**EXHIBITION OF ENVIRONMENTAL ASSESSMENT (EA)
STAGE 1 PROJECT APPLICATION AT THE SUMMER HILL FLOUR MILL REDEVELOPMENT
2-32 SMITH STREET, SUMMER HILL**

**CONCEPT PLAN FOR MIXED USE DEVELOPMENT
NO. 2-32 SMITH STREET, SUMMER HILLS**

ATTACHMENT A

Figure 8 Edward Street / Old Canterbury Road Intersection

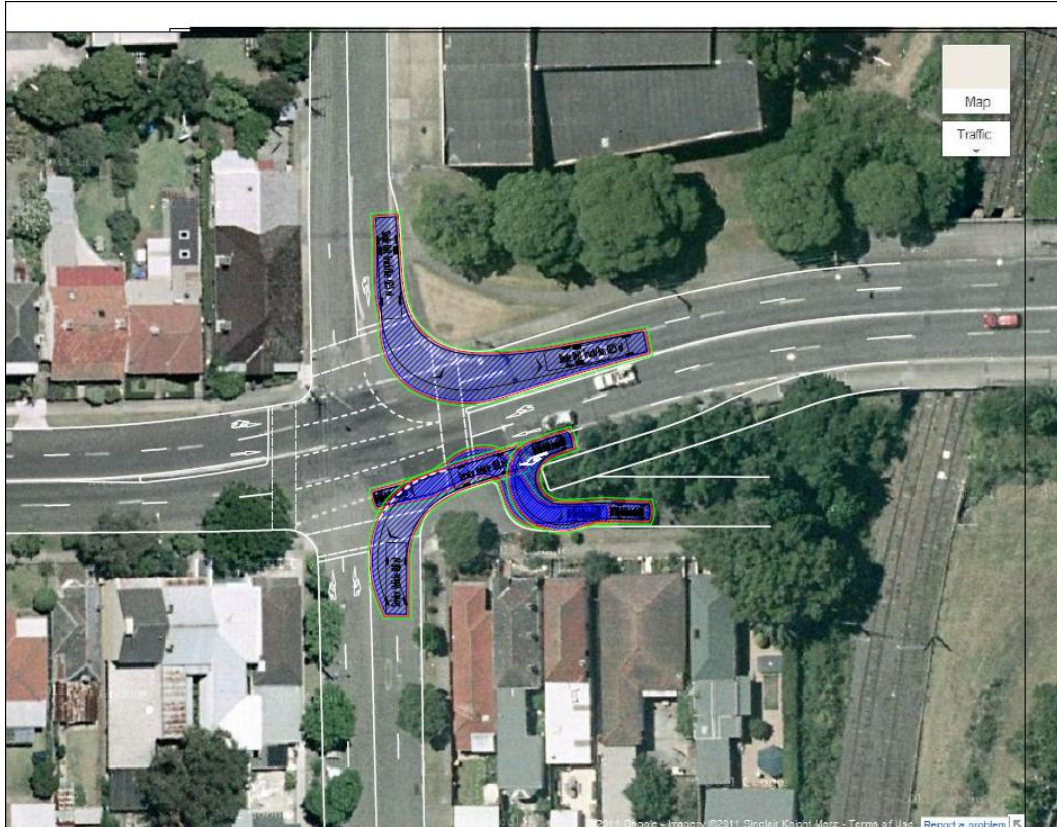
- It is recommended that the raised medians be removed as they are more of a hazard given that the existing alignment both horizontal and vertical is not the best and the medians are relatively short and the development of these medians is also short in length. The medians as shown are too narrow to cater for a signal post and widening the medians for the placement of signal posts will compromise the alignment. Recommend just use the existing barrier lines and lane line for the existing lanes. This will mean that where required mast arms are to be used.

- There is existing guardfence on the south western corner to provide protection to the houses directly on the corner. By providing the two signalised pedestrian crossing it will open up the guardfence and may become an issue with the property owners.

- Is there enough room in the footways on the north western and south western corners of the intersection to place signal posts/mast arms, kerb ramps, signage etc. as the footways are narrow in these locations.

- The access for the properties on the south eastern corner of the intersection should be designed to give right of way to pedestrians and cyclists. The concrete footpath should continue all the way and driveway crossings provided either side of the footpath. Basically it should be treated as a driveway to avoid confusion of give ways.

- The turn path for a car to turn into the access is quite tight, if there are cars parked at the entrance vehicles cannot enter. "No Stopping" signs shall be provided in this area?

- There is also a power pole with lighting and a drainage pit that will have to be relocated due to this proposed access.
- There are a number of power poles with overhead wires at the intersection. These need to be considered when placing any mast arms etc.

- Turn paths only show a 12.5m single unit truck/bus turning left from Edward Street into Old Canterbury Road and a 8.8m single unit truck turning left from Old Canterbury Road into Western Street. Will larger vehicles such as 14.5m buses be expected to make turns at this intersection due to the development?

- There are drainage pits located on some of the corners of the intersection that will need to be relocated as they will be in the way of the proposed signalised pedestrian crossings. And normal drainage requirements apply i.e. width of flow at the proposed crossings to be no more than 0.5m (confined to the gutter).

- No need for the T1 turn lines for the right turn and left turn movements. And there would probably be no need for the T1 lines through the intersection in Old Canterbury Road as the existing alignment will basically be used.
